From: Anita Gardner
Sent: 01 August 2019 17:19
To: Planning.Responses
Subject: FW: EP/64/19/DOC
Attachments: 4501_Marmont_EastPreston_DrainageLayout_F_REV A.pdf; 4501_Marmont_EastPreston_DrainageNetworkCalculations_F_REV A.pdf; 4501_Impermeable Area Plan.pdf

From: Ben Daine [REDACTED]
Sent: 15 July 2019 16:44
To: Anita Gardner <Anita.Gardner@arun.gov.uk>; Laura Gibbons <Laura.Gibbons@arun.gov.uk>
Subject: FW: EP/64/19/DOC

From: Oliver Harvey [REDACTED]
Sent: 12 July 2019 15:53
To: Guy Lower
Cc: Marmont Developments
Subject: RE: EP/64/19/DOC

Drawing No: X:\PROJECTS\4501_Marmont_EastPreston\Plans\4501_Marmont_EastPreston_DrainageLayout.dwg

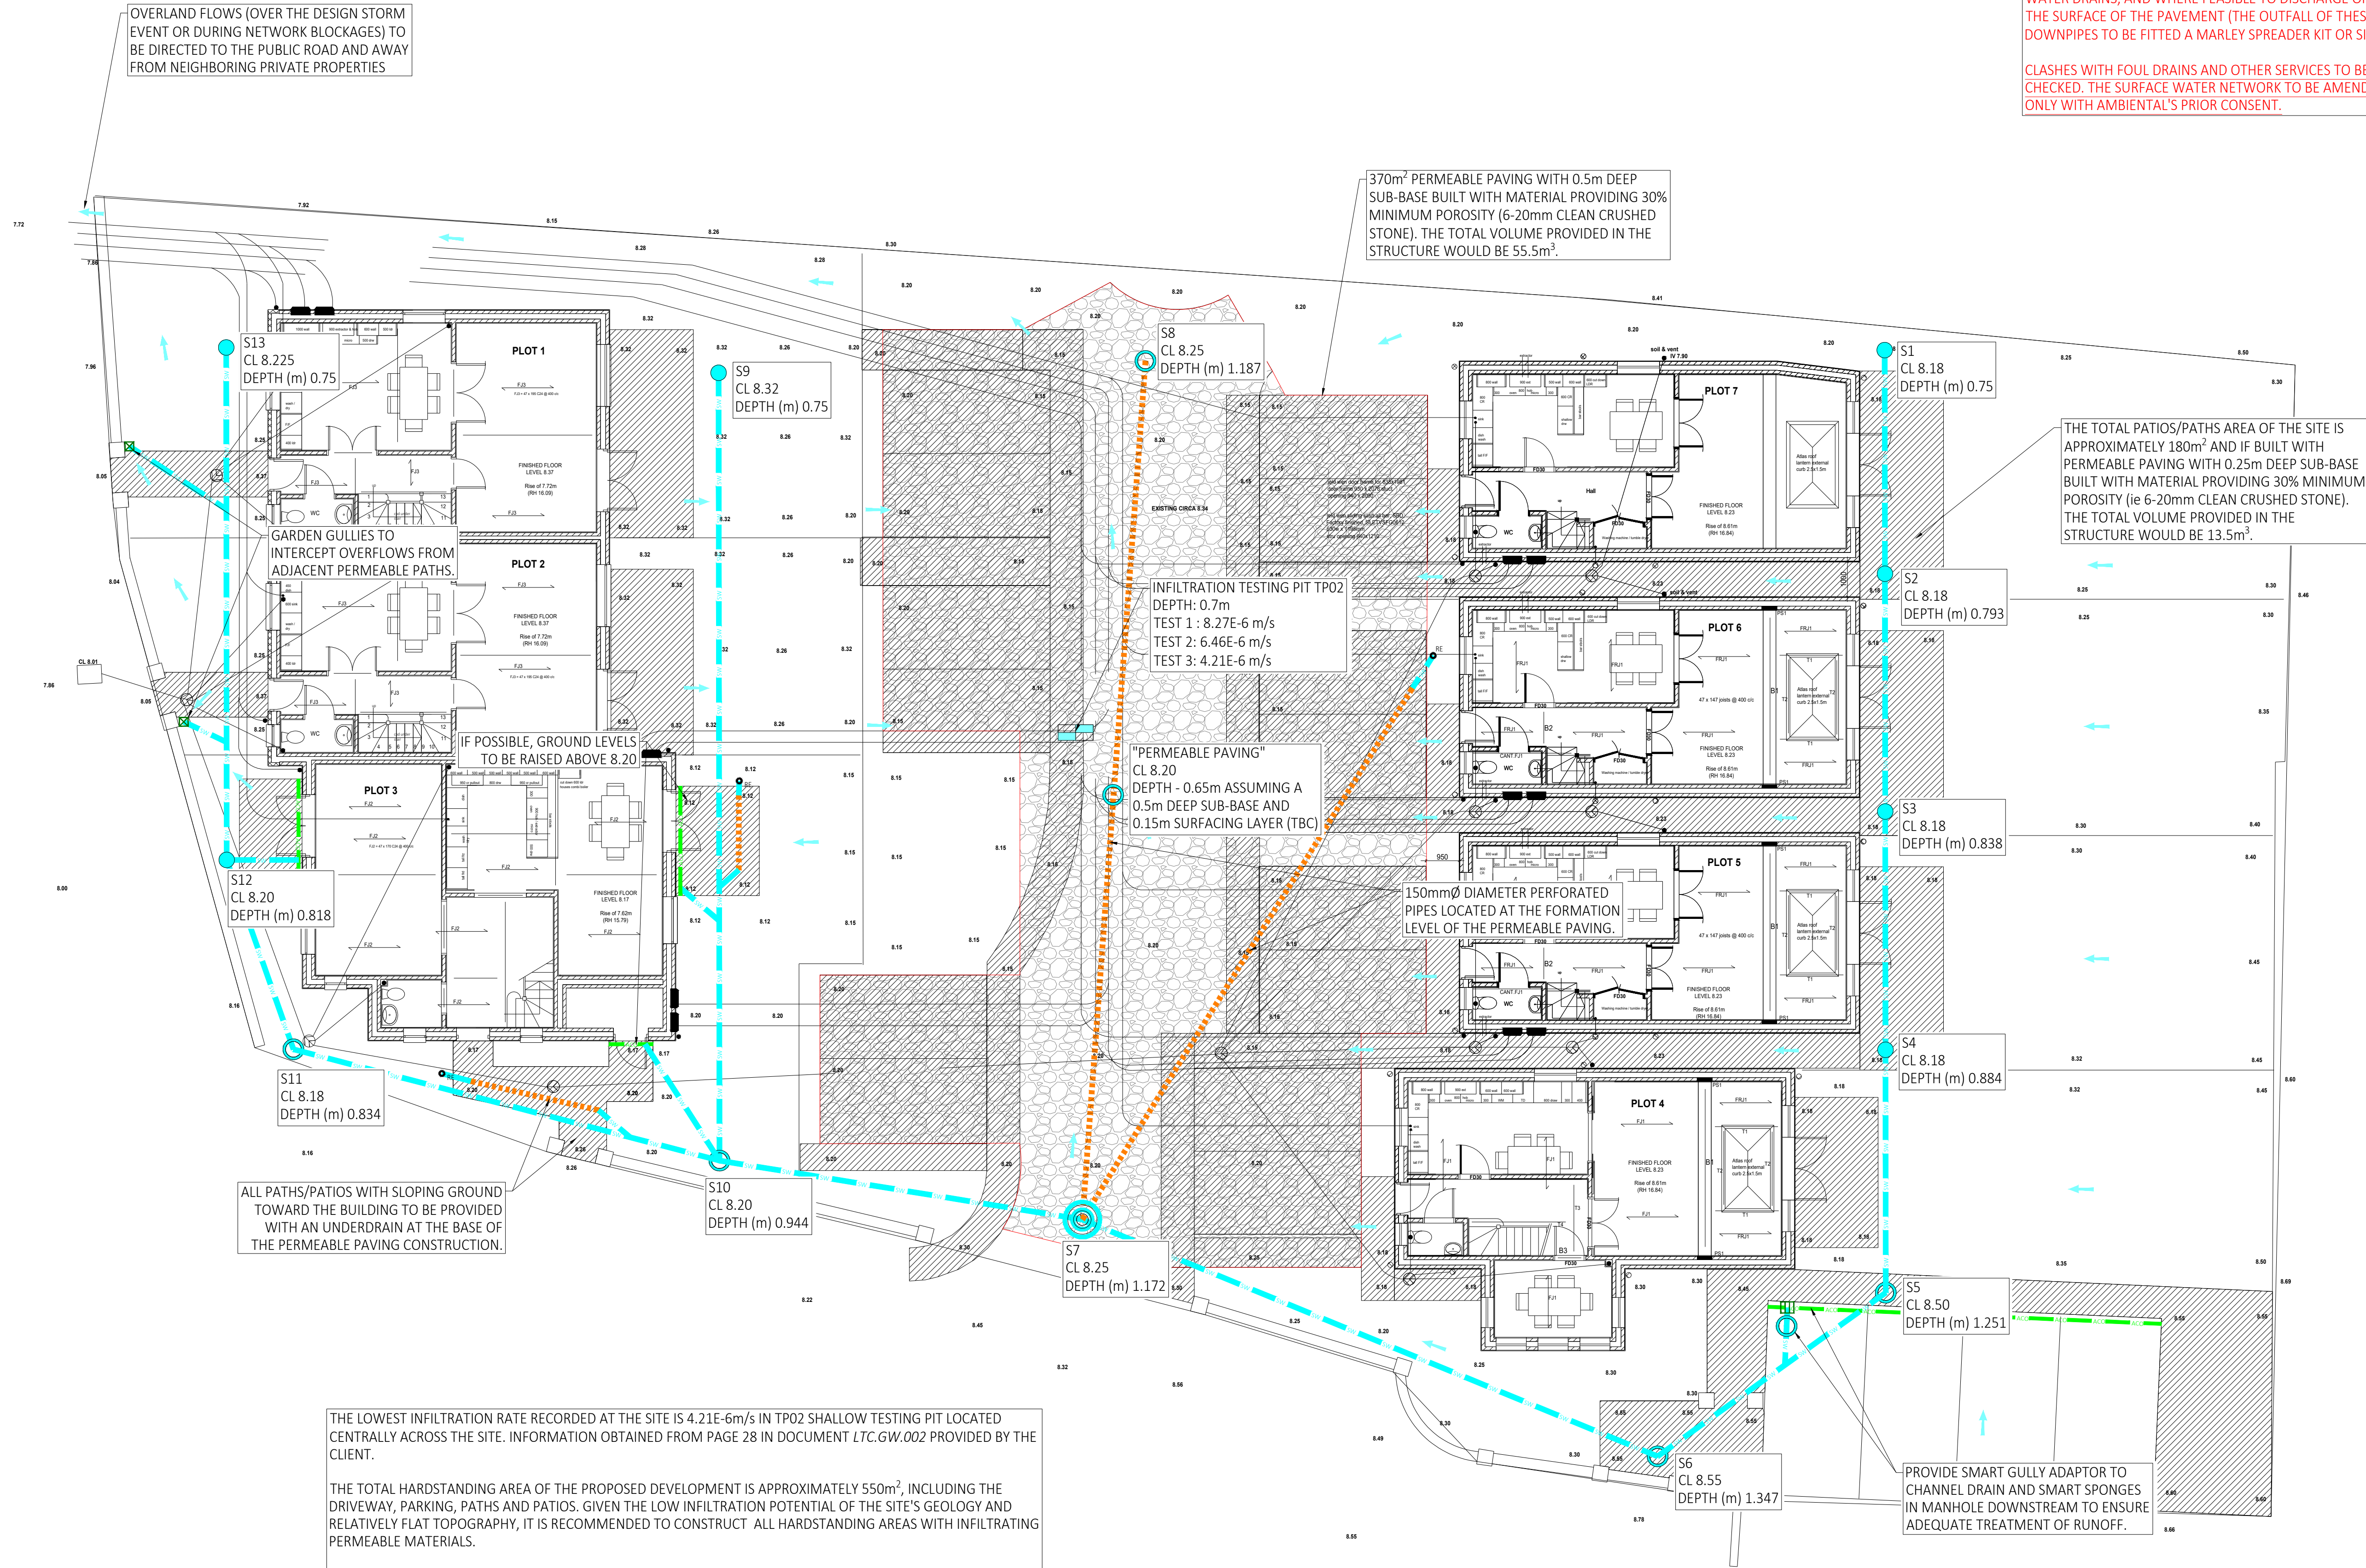
1. Layouts need to clearly identify the formation and finish level proposed for permeable paving. On drawing & section detail
2. Please can invert levels and not depths be expressed at each manhole. Added

3. The size and fall of all pipes needs to be clearly labelled on the plan. Added
4. Catchpit locations need to be clearly marked on the plan. Added
5. The factor of safety used in calculations needs to be revised to be compliant with requirements set out within CIRIA. Please refer to our checklist for further information on this. Used CV=1 and FoS = 3, this increased storage with approx. 30%. Added a geocellular tank to the side of the pavement in the soft landscaping to make up for it, see section detail on drawing.

6. Please can an impermeable area plan be provided. in link
7. Please can pipe numbers used in calculations be provided on the layout to facilitate my review. Added

INDICATIVE PERMEABLE PAVING AND GEOCELLULAR SYSTEM DETAIL
(SCALE 1:20 - NOT FOR CONSTRUCTION)

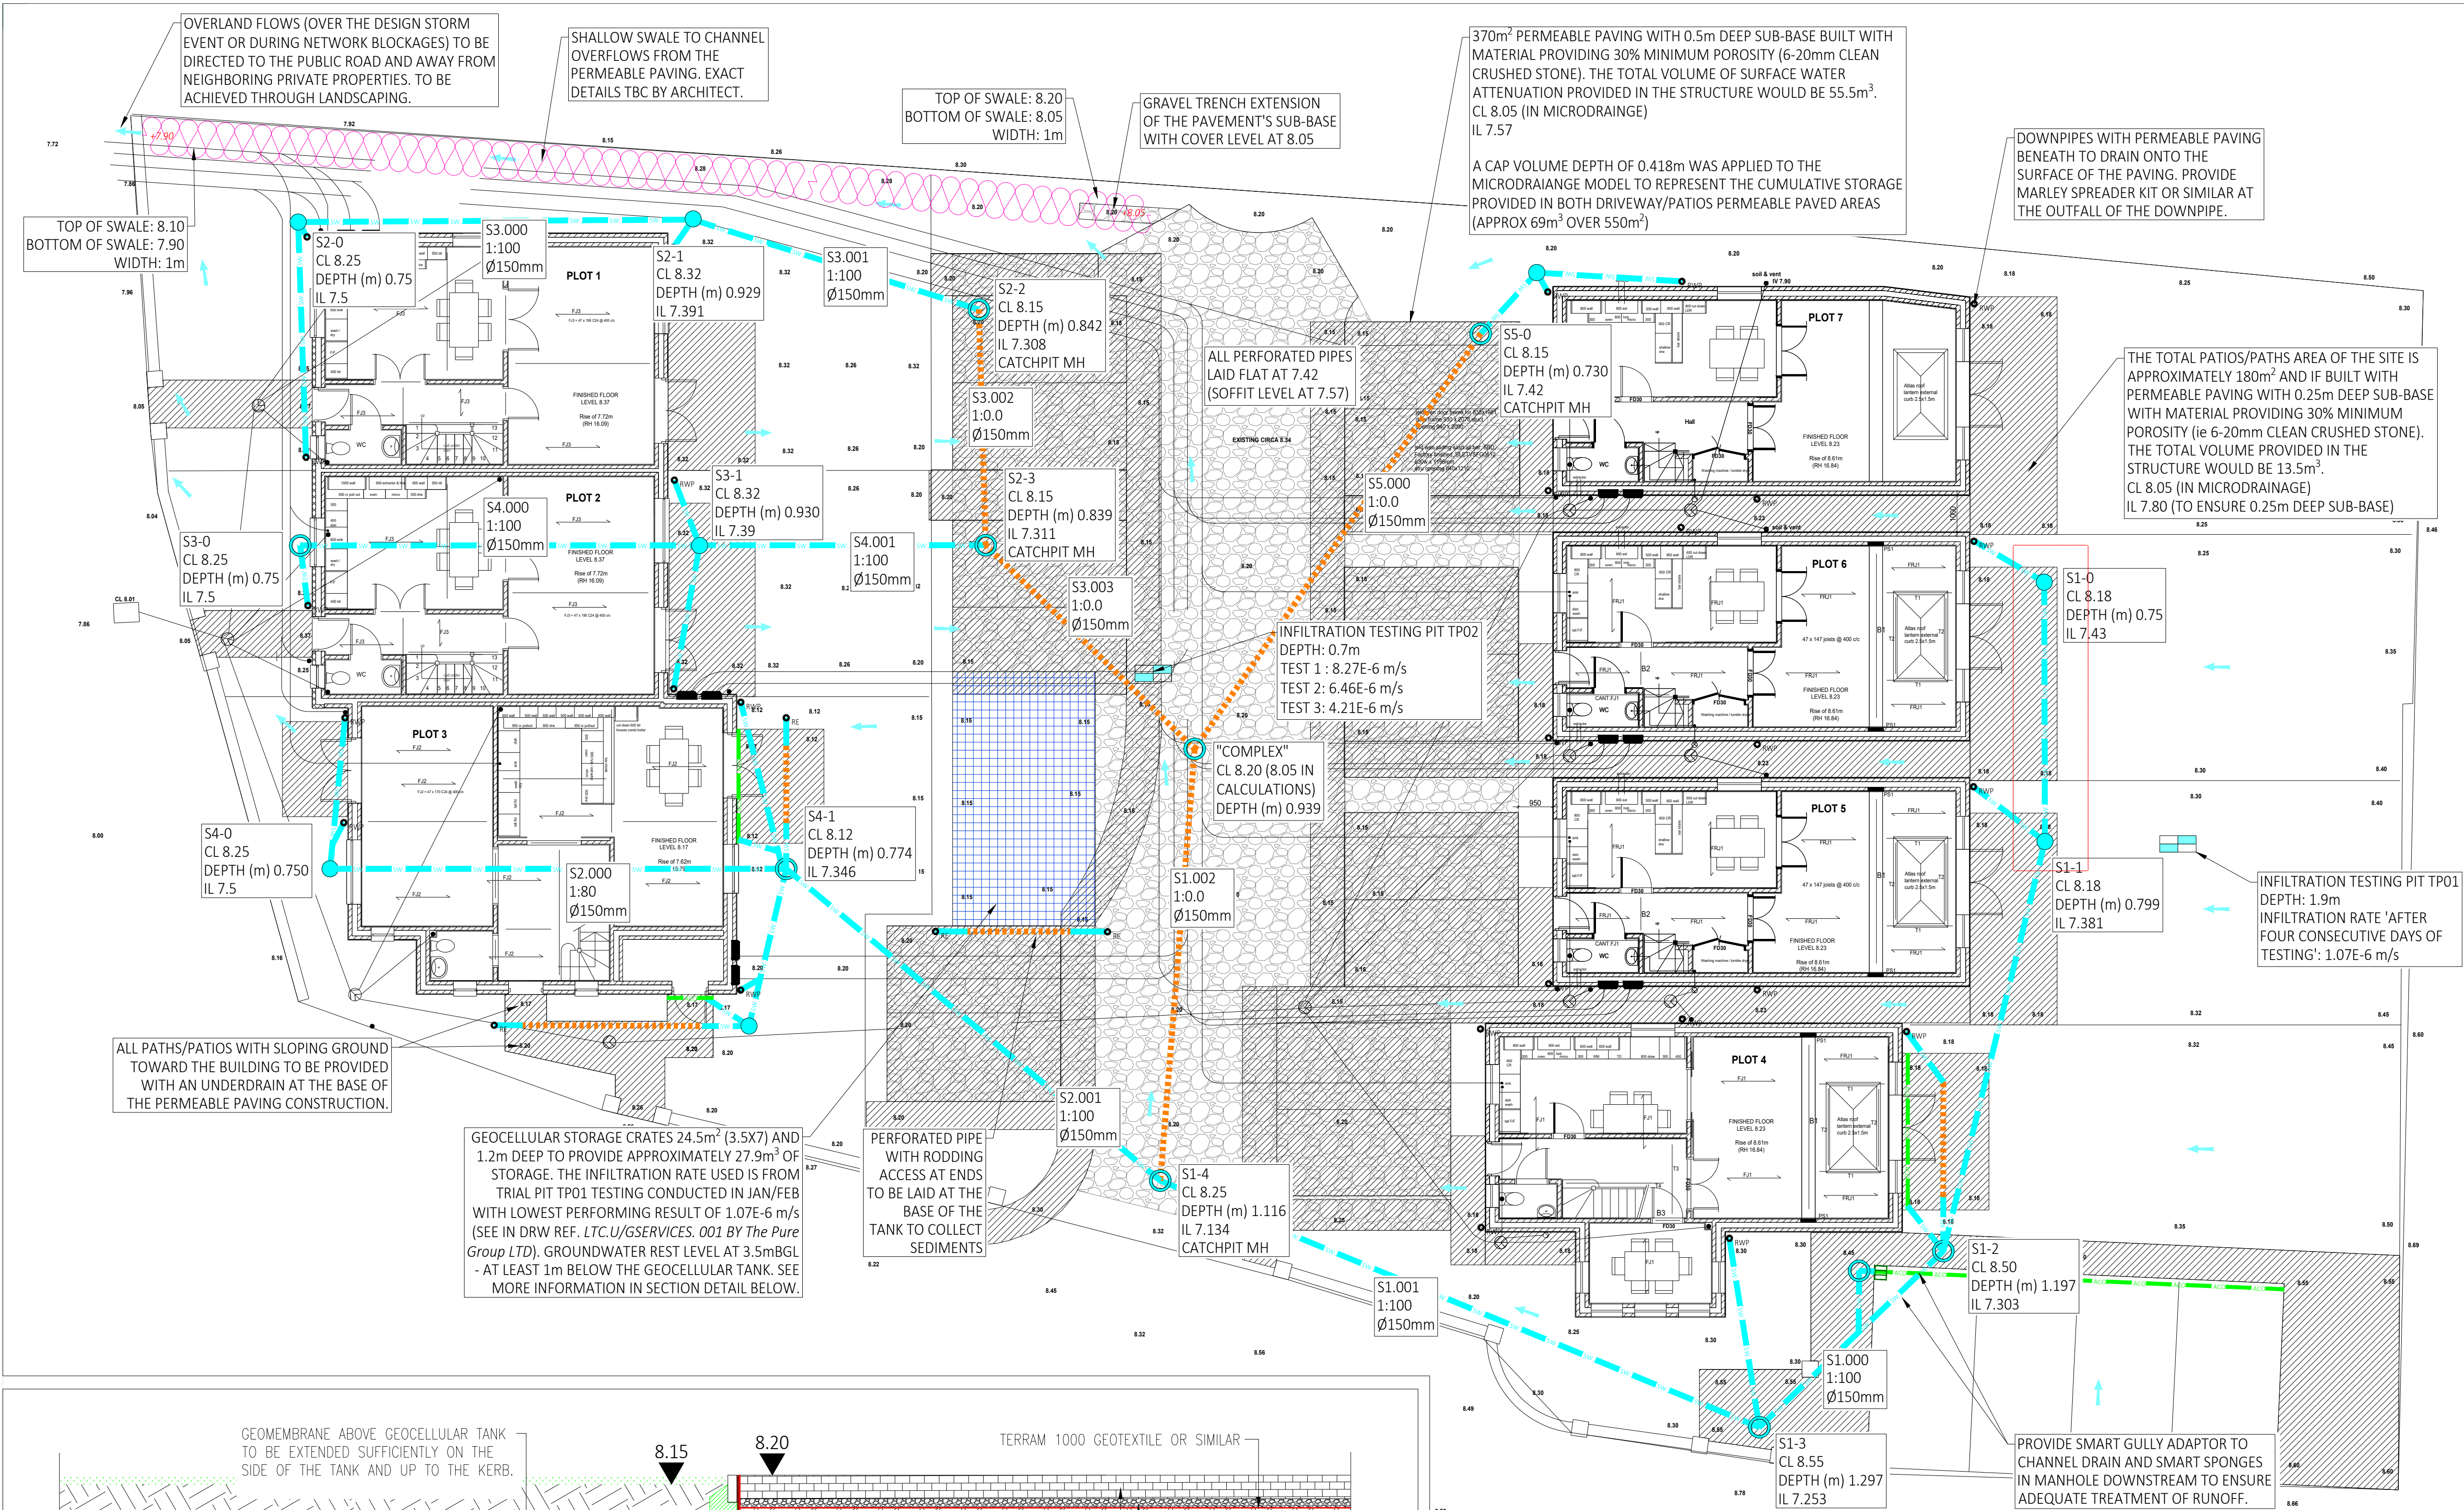
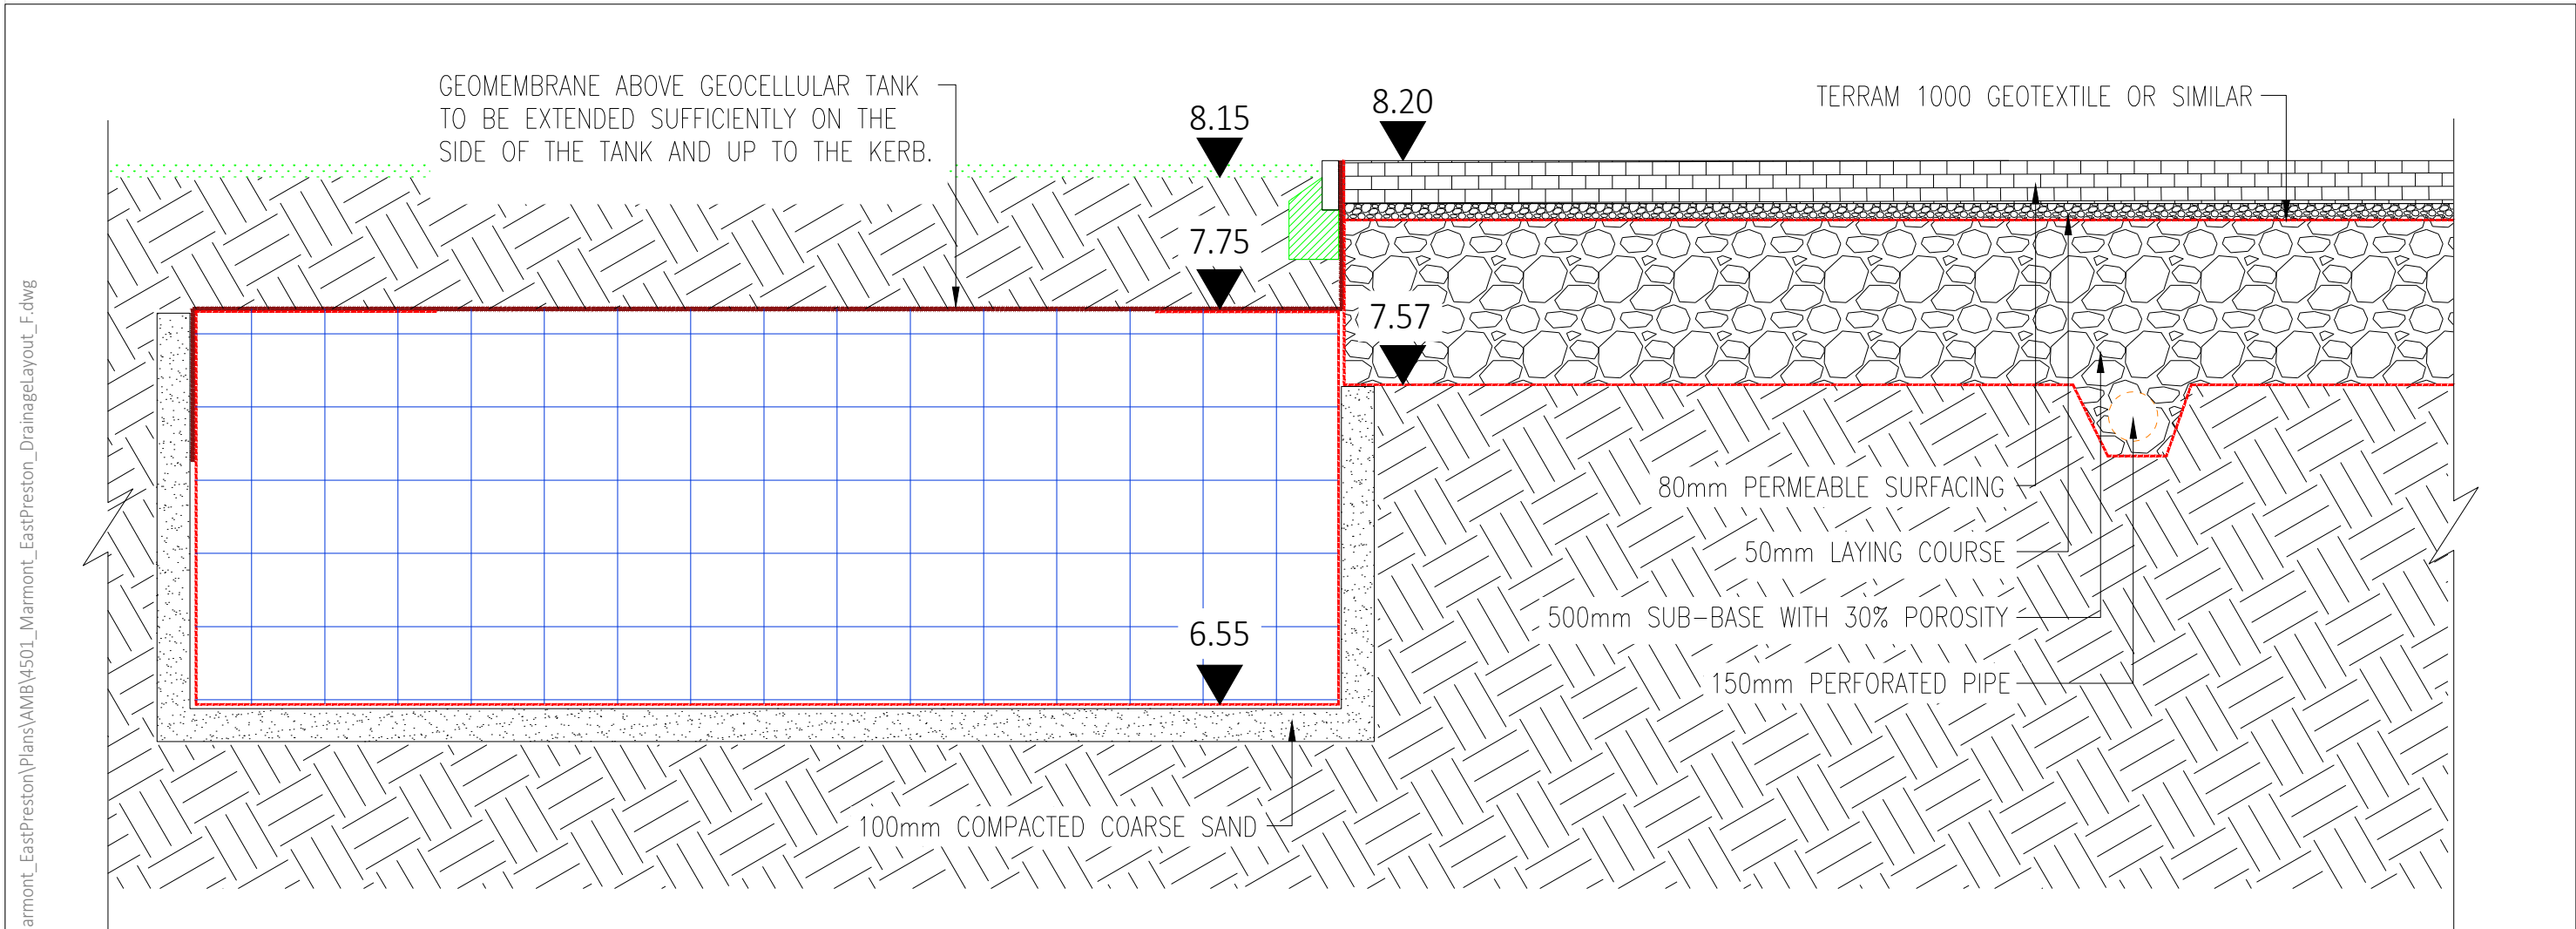
8. The invert level of the permeable paving modelled is incorrect. Please can a cap volume depth also be modelled. Used 0.418m cap to reflect the attenuation storage throughout the site, both in the 0.5m and 0.25m deep regions - $(55.5m^3 + 13.5m^3) / ((370m^2 + 180m^2) \times 0.3)$
